**EL PASO COUNTY PLANNING AND
 COMMUNITY DEVELOPMENT
 DEPARTMENT**

SIGN PLAN CHECKLIST

Include Title:
Sign Plan
File No. PPR2349

FOX RUN NATURE CENTER

SHEET:
DP3.1

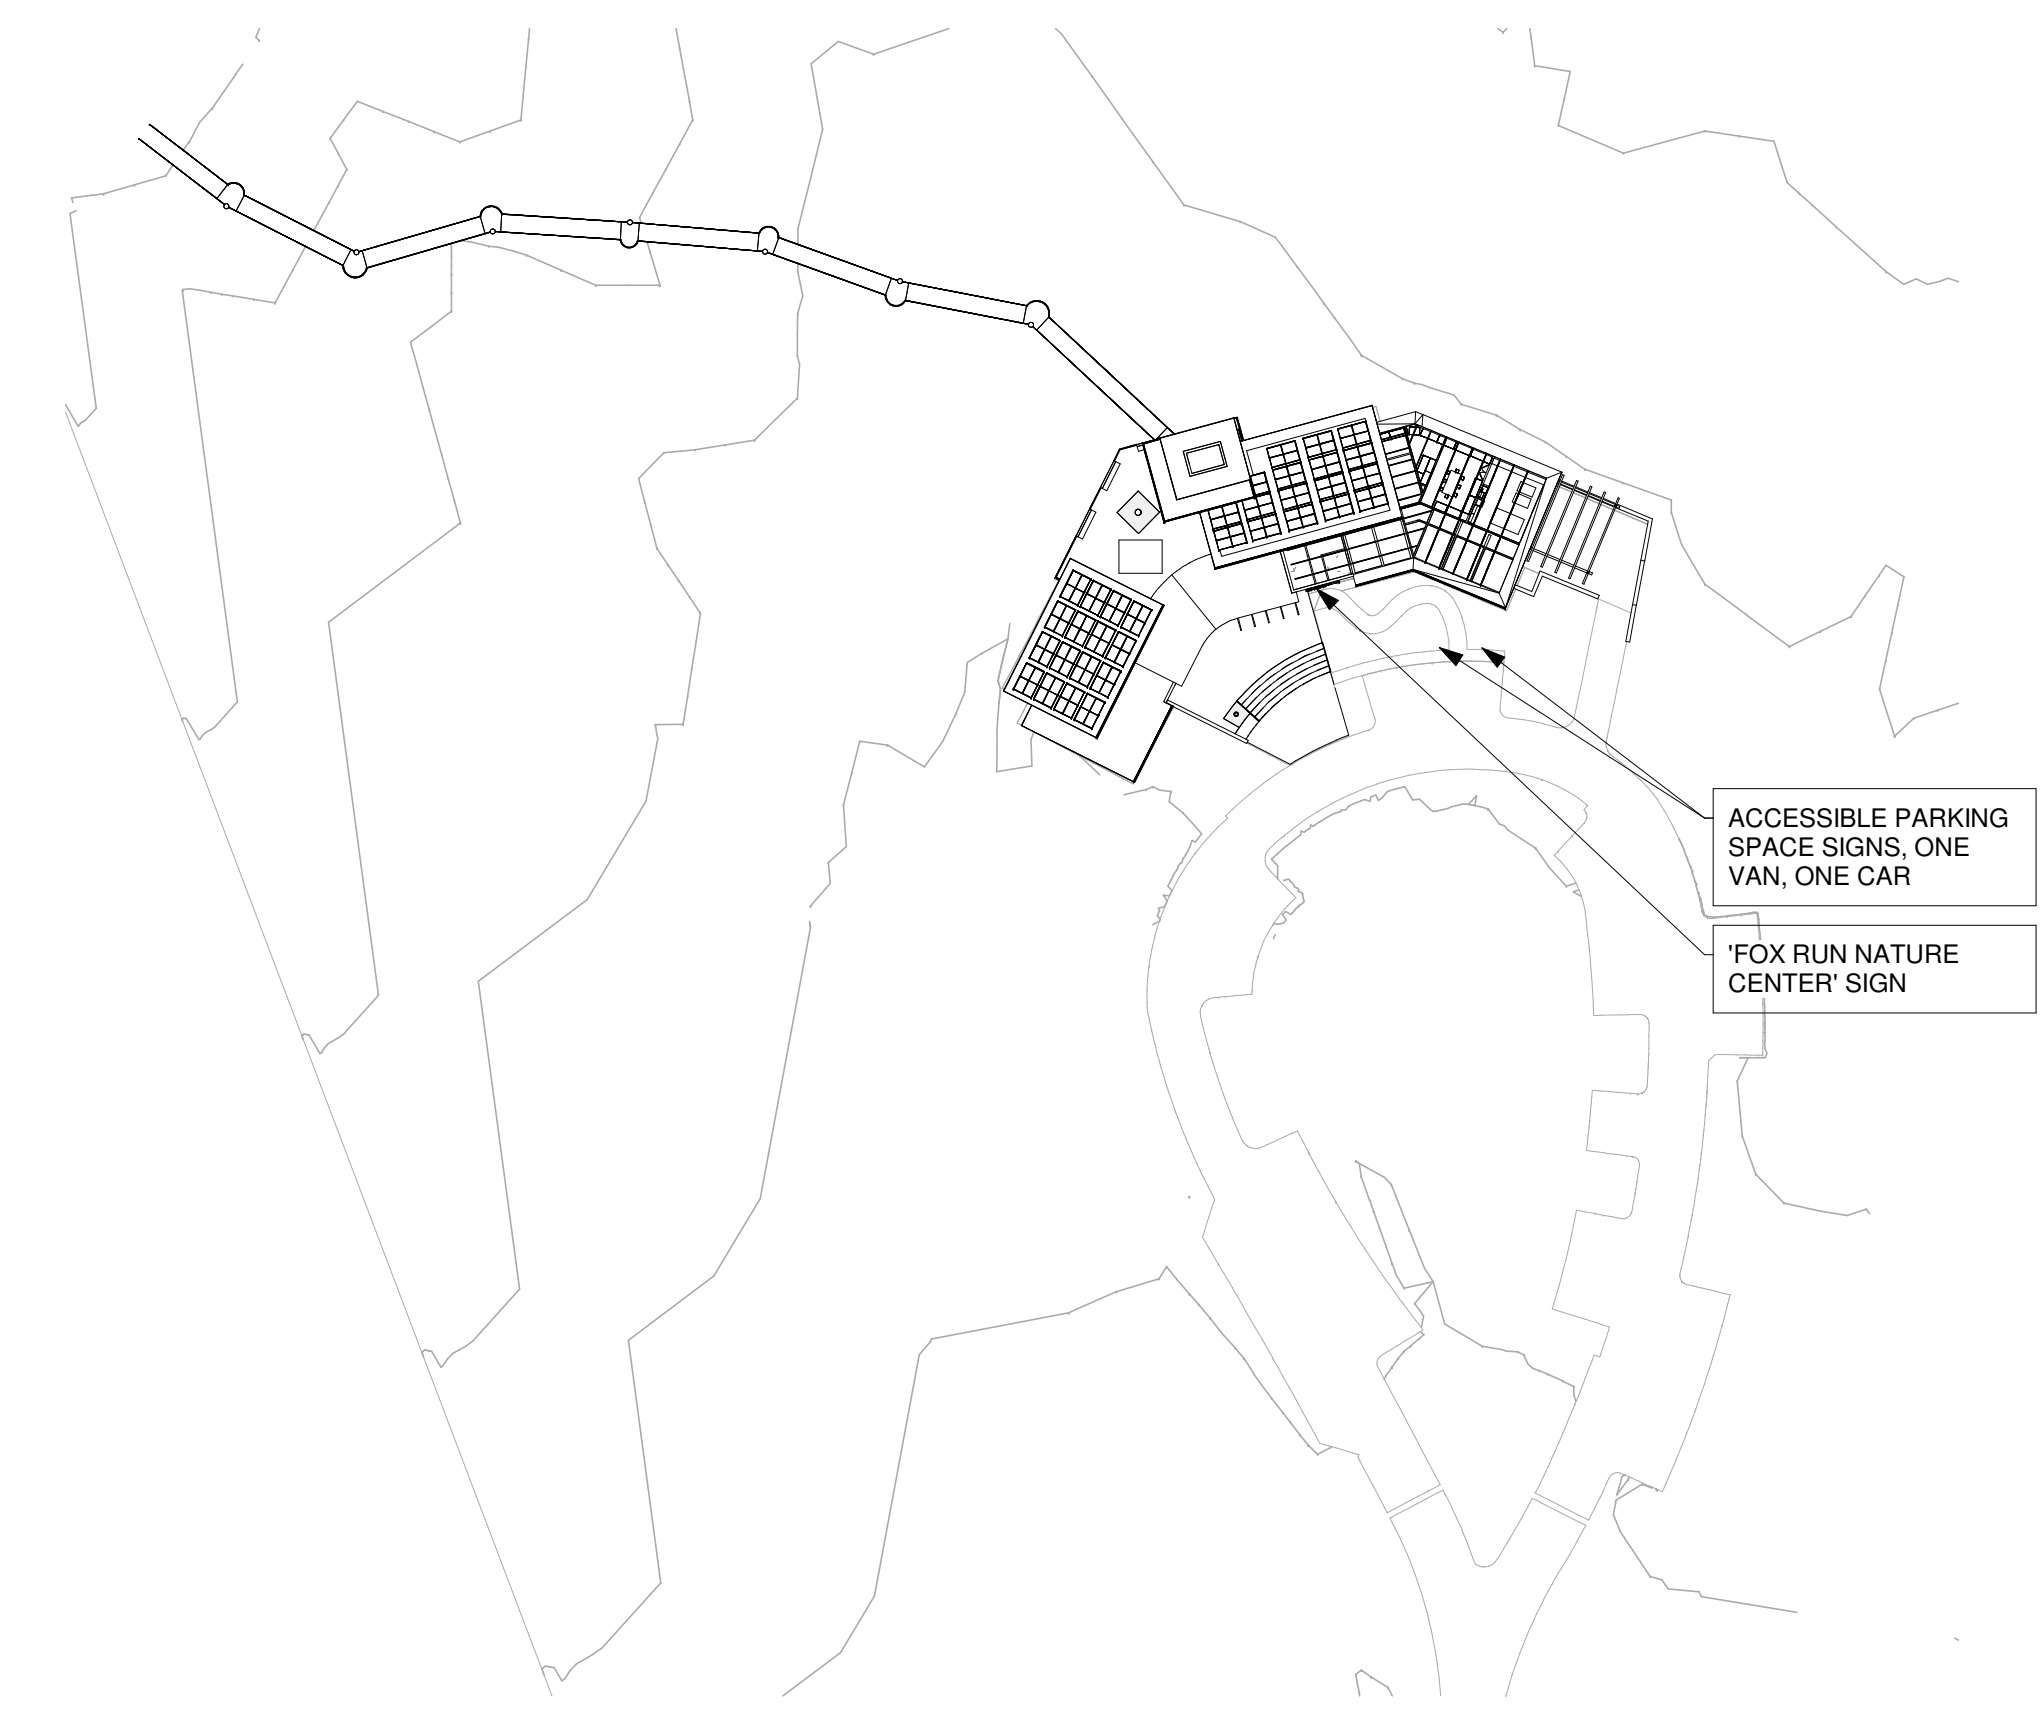
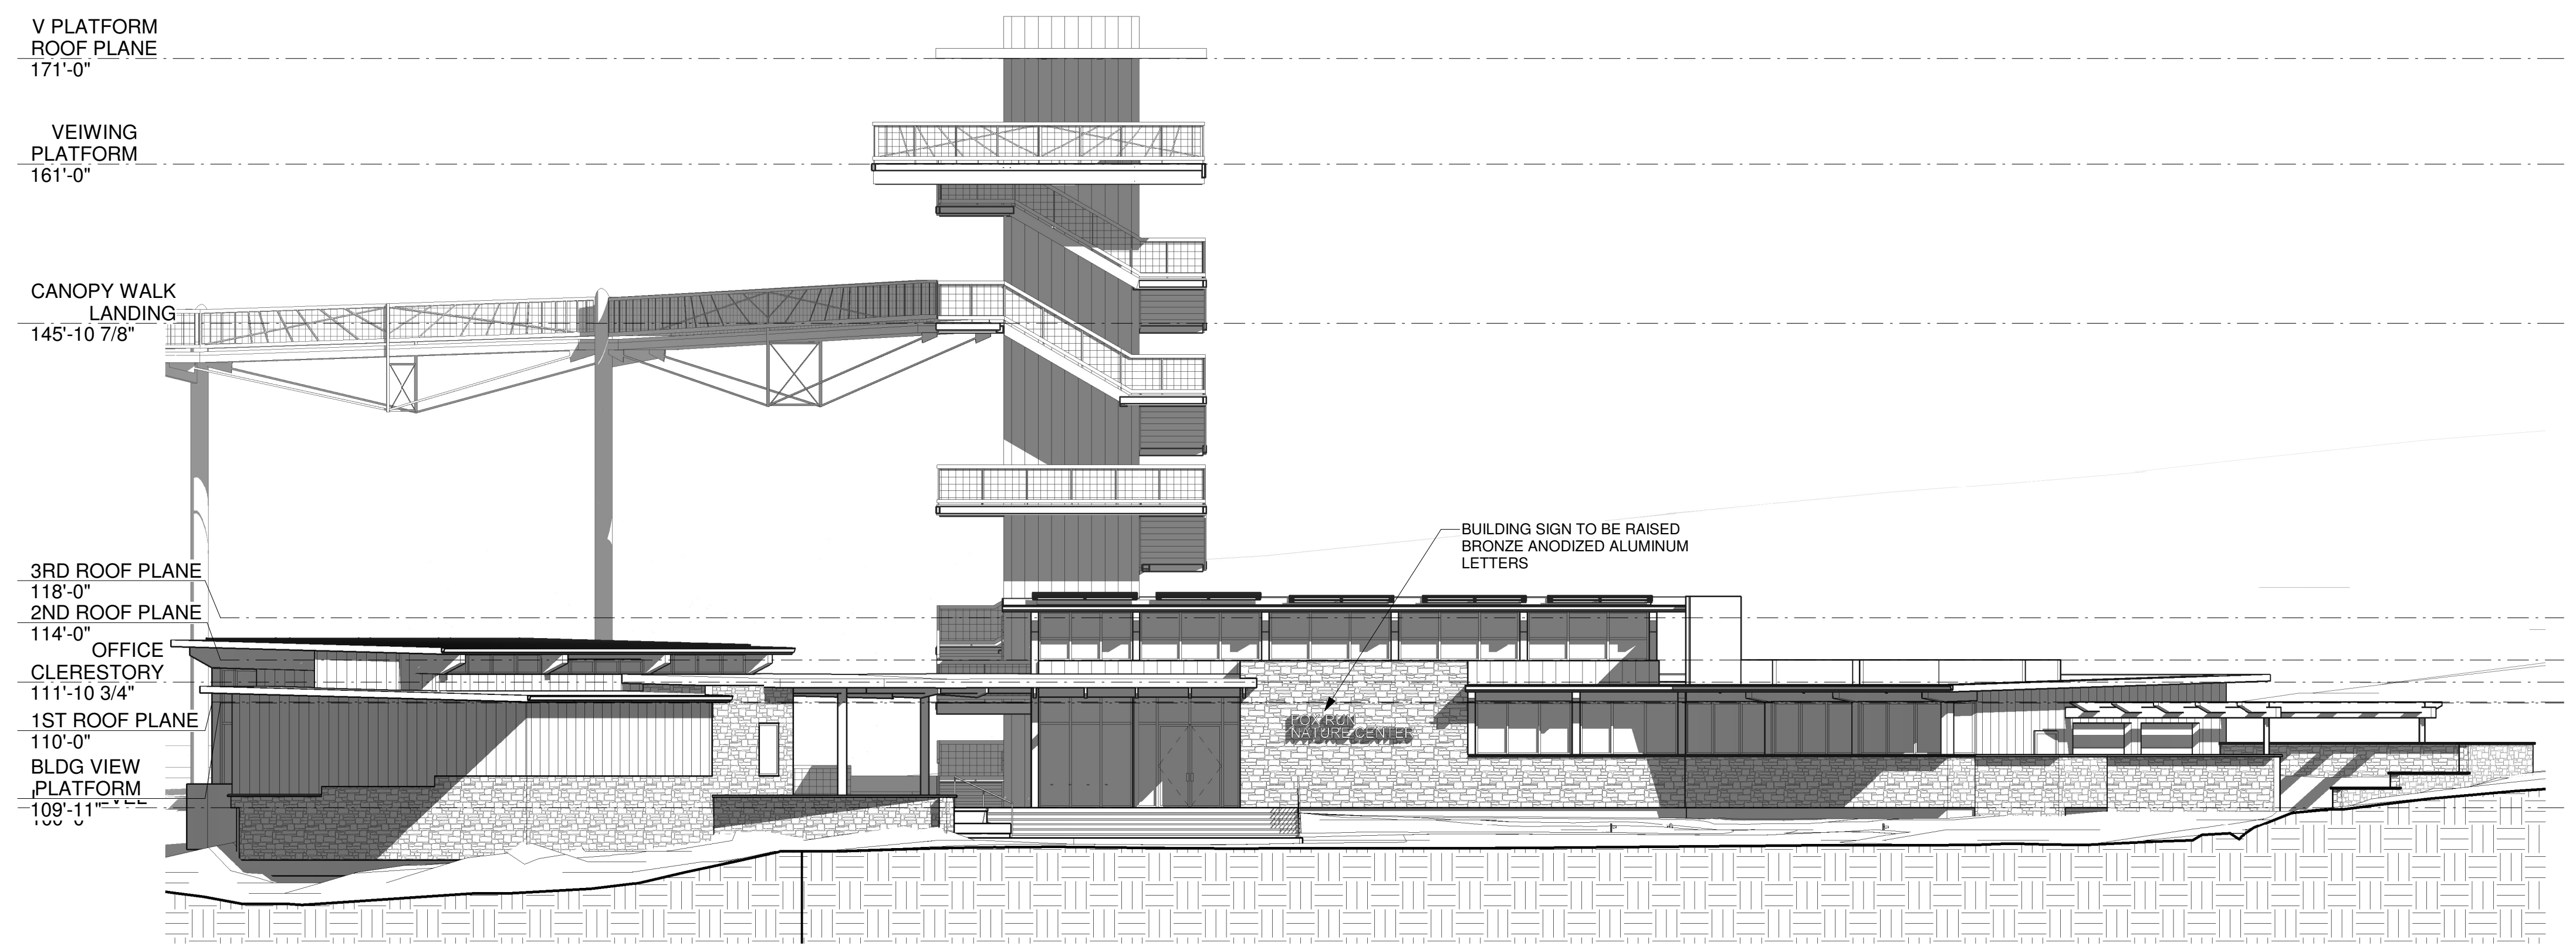
Please include:
 -Summary of square footage of the total allowed signage and existing and proposed signage for the property
 -Include note about whether sign is illuminated or not
